## KITTITAS COUNTY COMMUNITY DEVELOPMENT SERVICES

**Subject: Palomino Fields Div 2 (LPF-19-00003) Final Long Plat – Return to Applicant, Second Review, Additional Information Required.**

LP - 19-00003

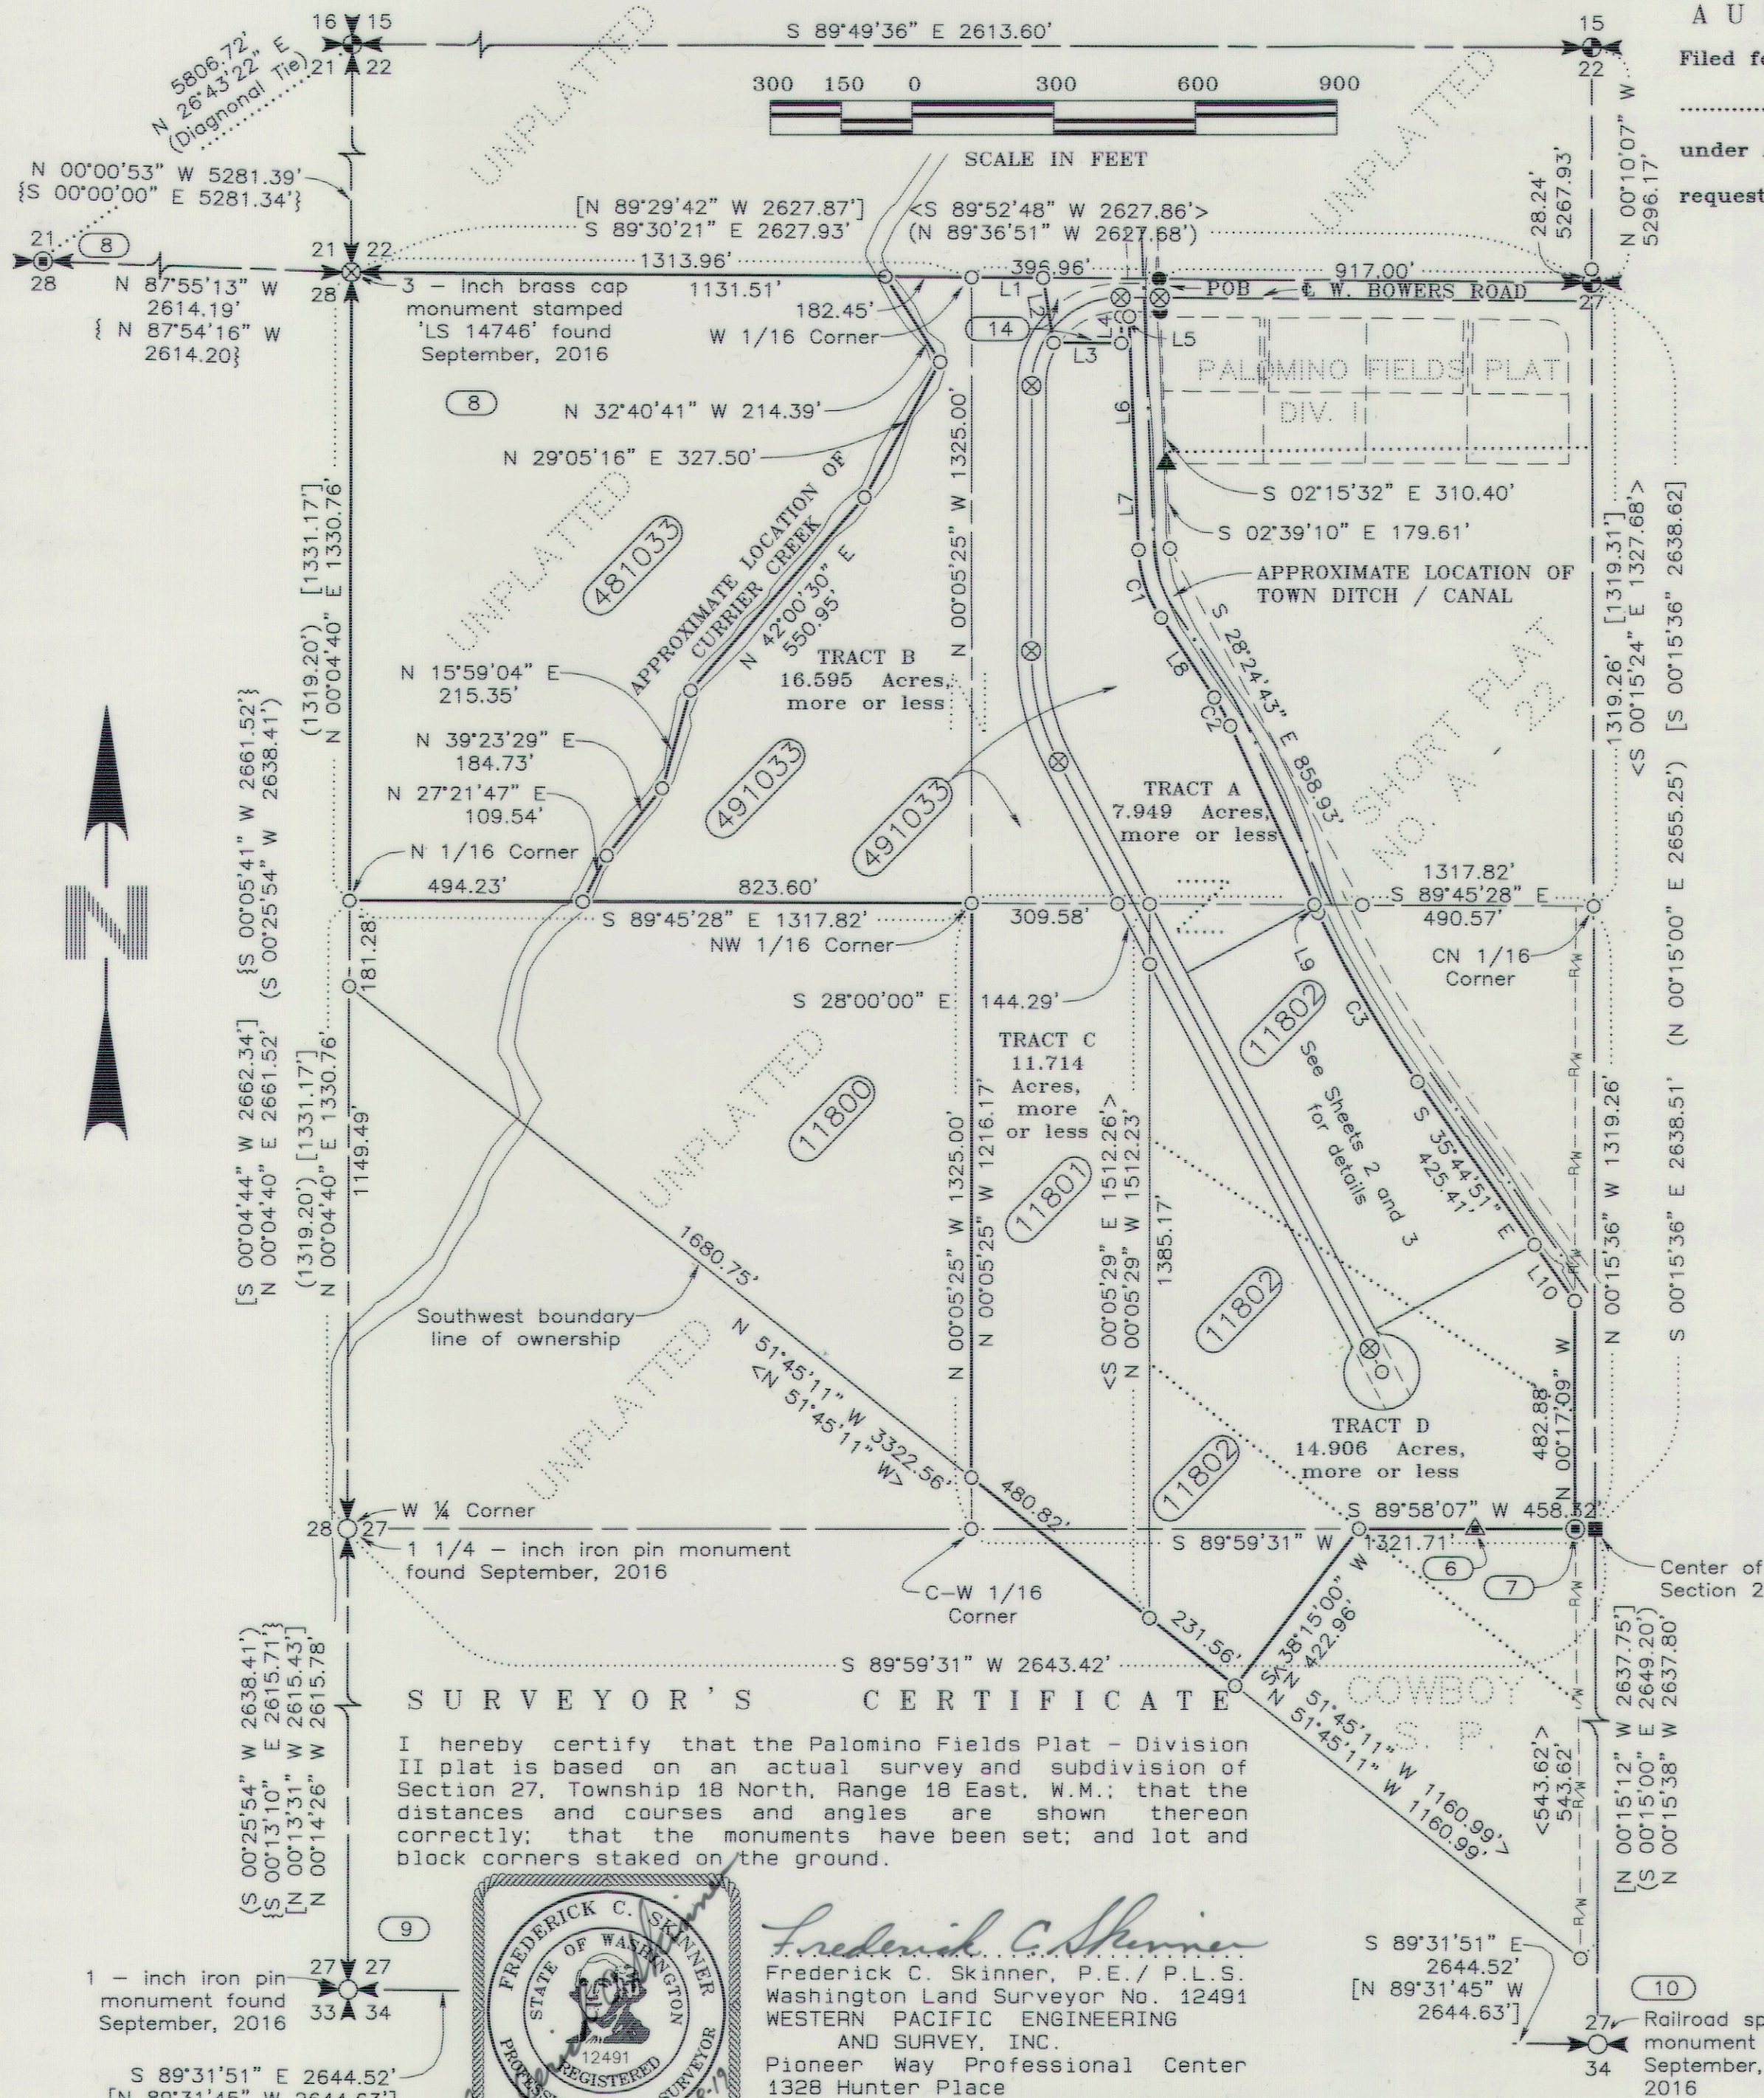
On April 22, 2019 CDS received your final mylar submission that included changes based on the first round of County review. The final mylars were routed to Kittitas County Public Works for a final review. Pursuant to the comments provided by Kittitas County Public Works on April 25, 2019 (see attached) this final plat submittal has not met all of the necessary requirements for final plat approval. RCW 58.17.140 states, "Final plats and short plats shall be approved, disapproved, or returned to the applicant within thirty days from the date of filing." CDS is returning your application to allow an opportunity for the application materials to address all preliminary plat conditions and review comments/requirements. In addition to the comments from Kittitas County Public Works, the file number provided on the face of the plat reads "LP-19-00003". This should read "LPF-19-00003" and "LP-07-00031".
